The Woodland Trust would like to lodge a further objection to this application on account of likely additional loss or damage to a potential ancient tree located within proximity to the proposed Flyup 417 Bike Park access track, as outlined in the applicant's deadline 8 submission (reference: REP8-029).

**Figure 6-1** Screen shot from Trees and hedgerows to be removed or managed APFP Regulation 5(2)(o) Sheet 1 of 6

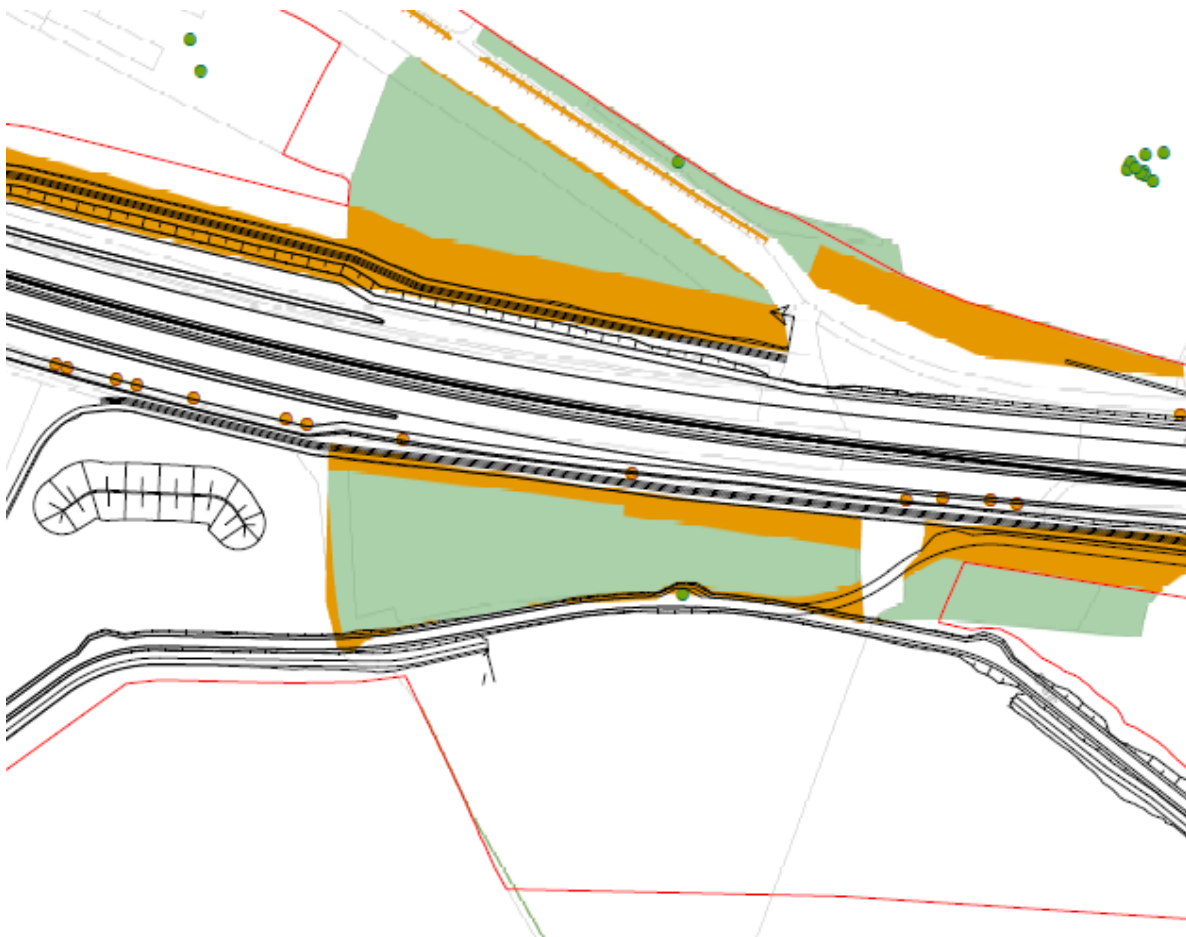
In line with the recommendations outlined in our written representation regarding ancient and veteran tree protection (REP1-136), the applicant should look to ensure that the ancient tree is retained and afforded an un-encroached root protection area in line with Natural England and Forestry Commission's Standing Advice. This guidance has recently been updated (14th January 2022) and now states:

“For ancient or veteran trees (including those on the woodland boundary), the buffer zone should be at least 15 times larger than the diameter of the tree. The buffer zone should be 5 metres from the edge of the tree's canopy if that area is larger than 15 times the tree's diameter. This will create a minimum root protection area.

Where assessment shows other impacts are likely to extend beyond this distance, the proposal is likely to need a larger buffer zone.”
